Howerton Services, PLLC
License # P-1716
3513 Cathedral Bell Road
Raleigh, NC 27614
(919) 270-3460

May 31, 2023

Subject: 109 Overlook Court
Angier, NC 27501
Framing Inspection Letter
Harnett County Permit #: SFD2012-0036

FIRST FLOOR PLAN
 SCALE : 1/4"=1'-0"
 BASEMENT HEATED AREA : 1755 SQ. FT.
 FIRST FLOOR HEATED AREA : 2140 SQ. FT.
 SECOND FLOOR HEATED AREA : 1672 SQ. FT.
 TOTAL HEATED AREA : 5567 SQ. FT. IN BRICK, SIDING & STONE VENEER

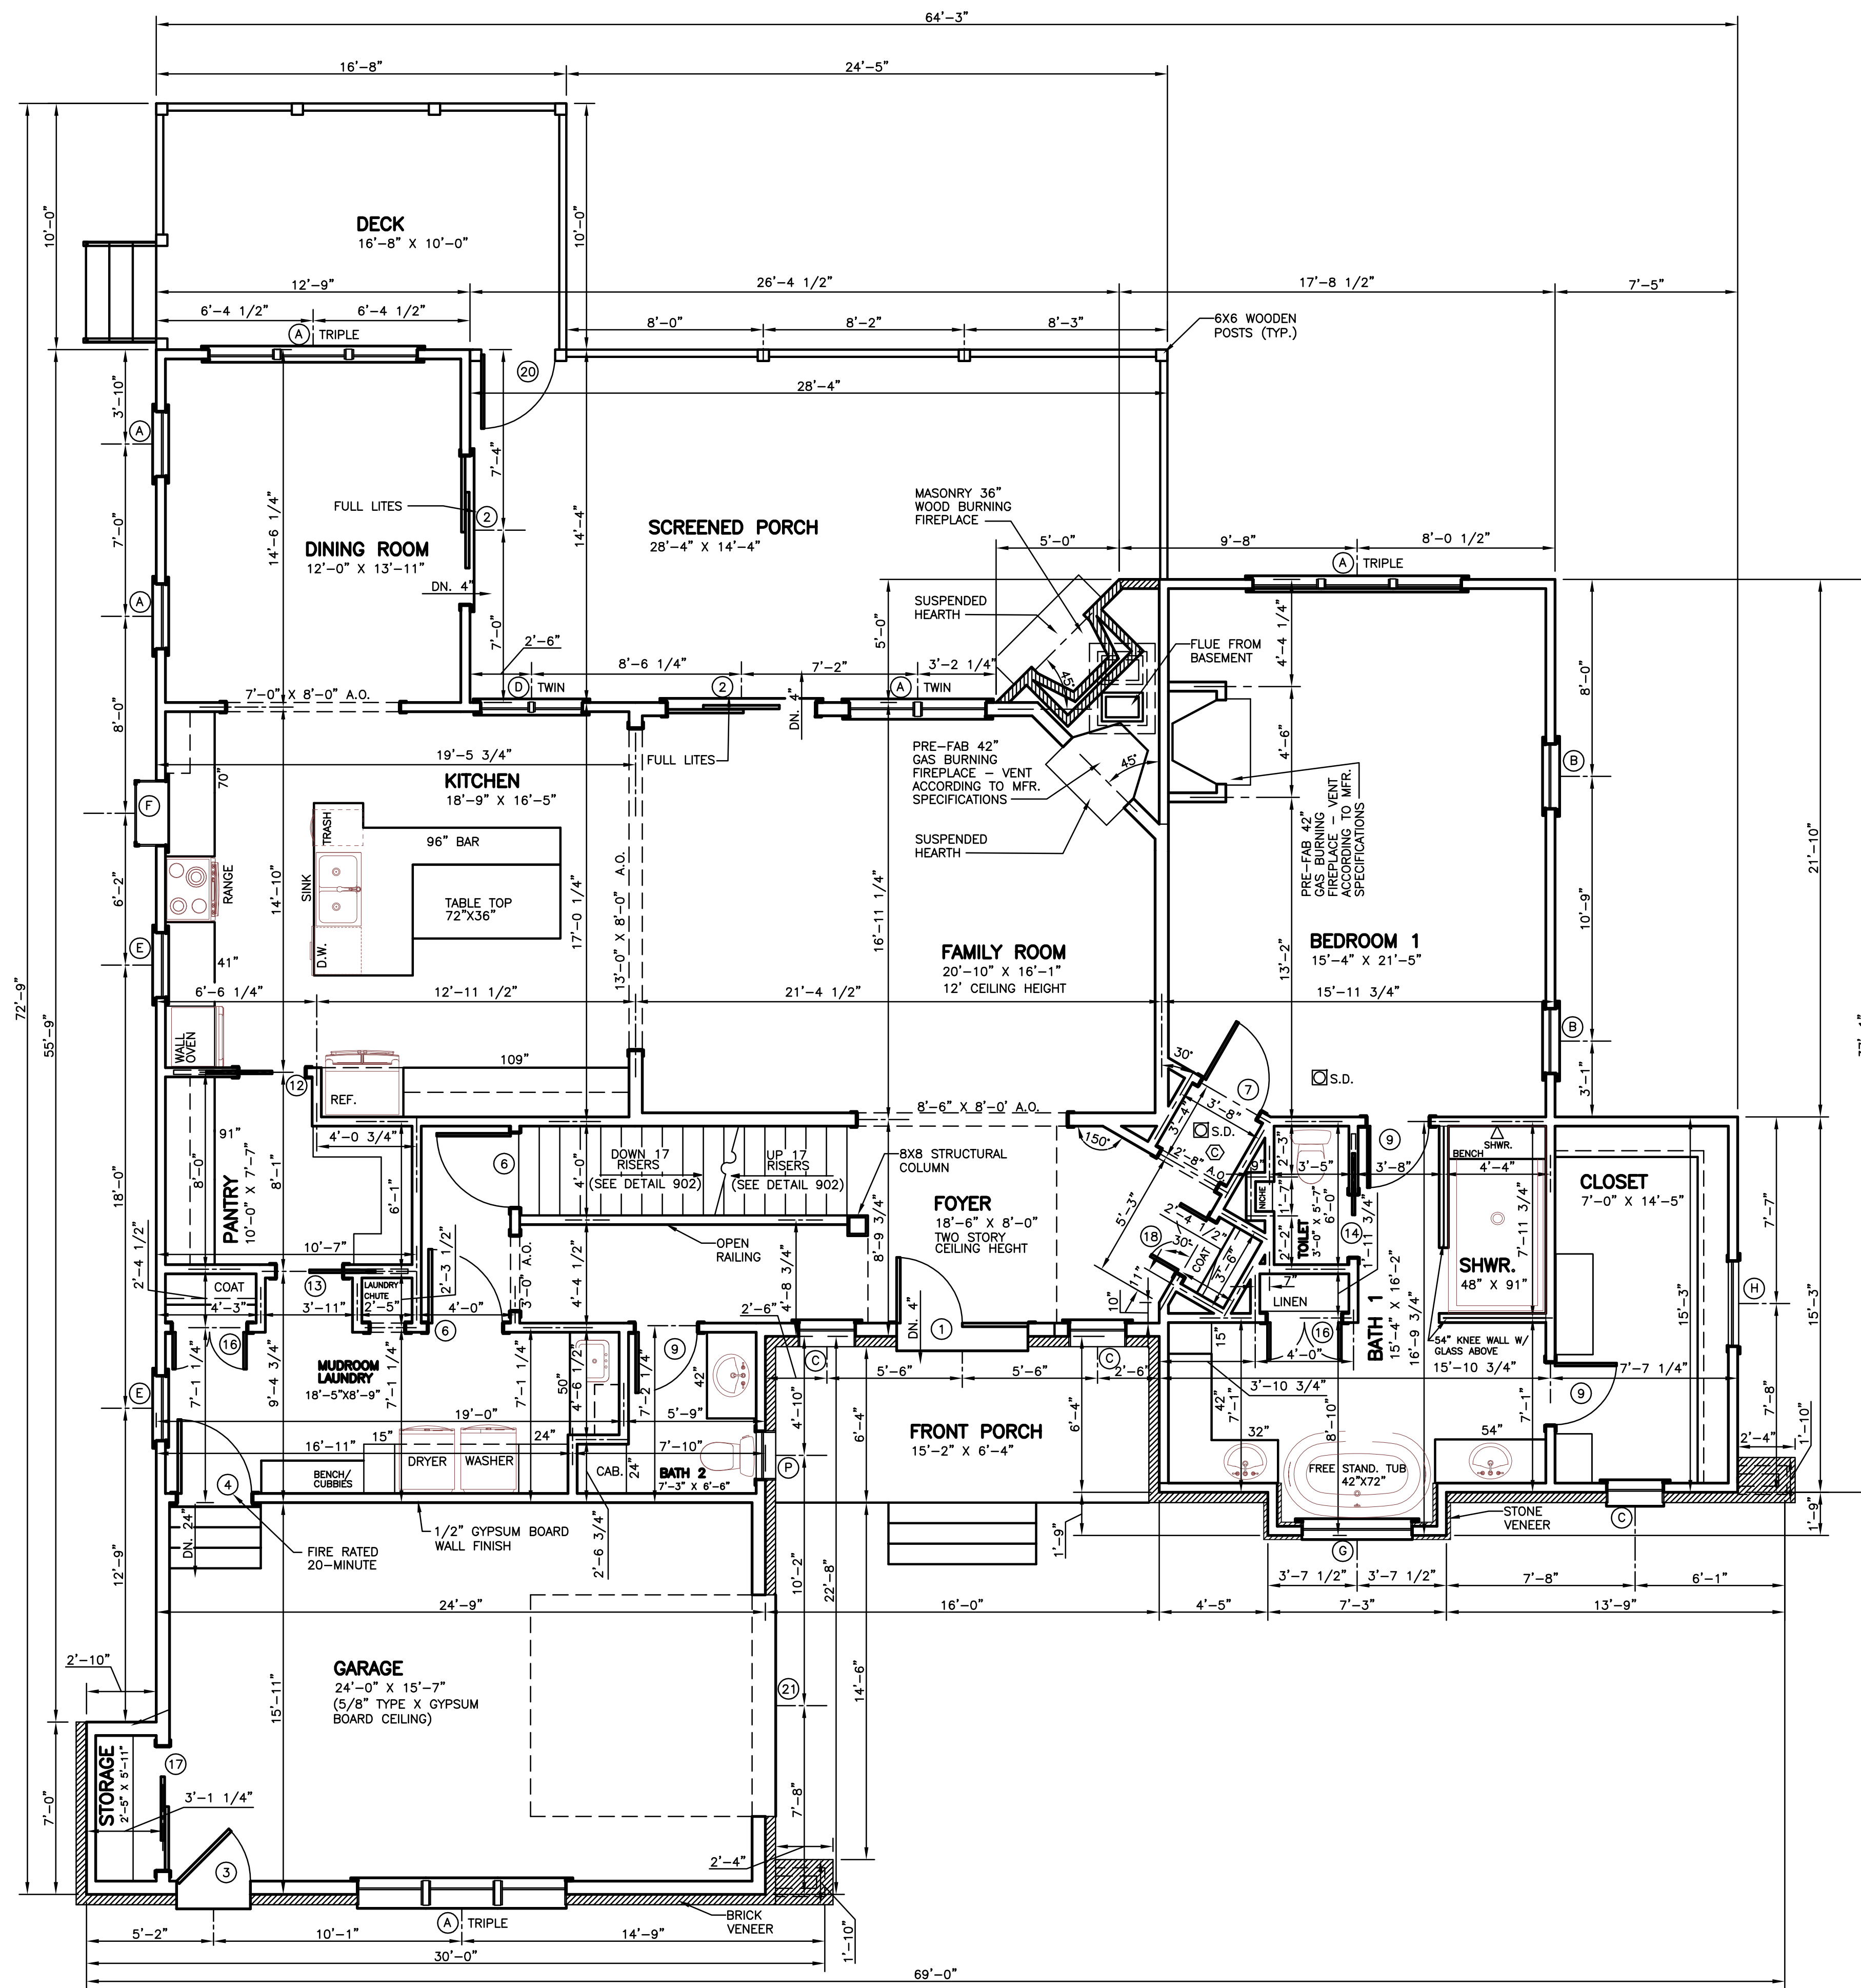
- Item 3: The installed engineered hangers are Mitek brand in lieu of Simpson hangers. The Mitek engineered hangers installed throughout the home are acceptable.
- Item 6: The double 1 3/4" x 9 1/4" LVL header was installed for the back left window on the main floor. The LVL was installed in lieu of the double 2x10s with stud pockets. This header modification is acceptable.
- Item 8: The quad 9 1/4" LVL with stud column support was removed from the ceiling of the back right room on the 2nd floor. Additional rafter supports and collar ties were installed in lieu of the LVL beam and the stud column. This modification is acceptable.
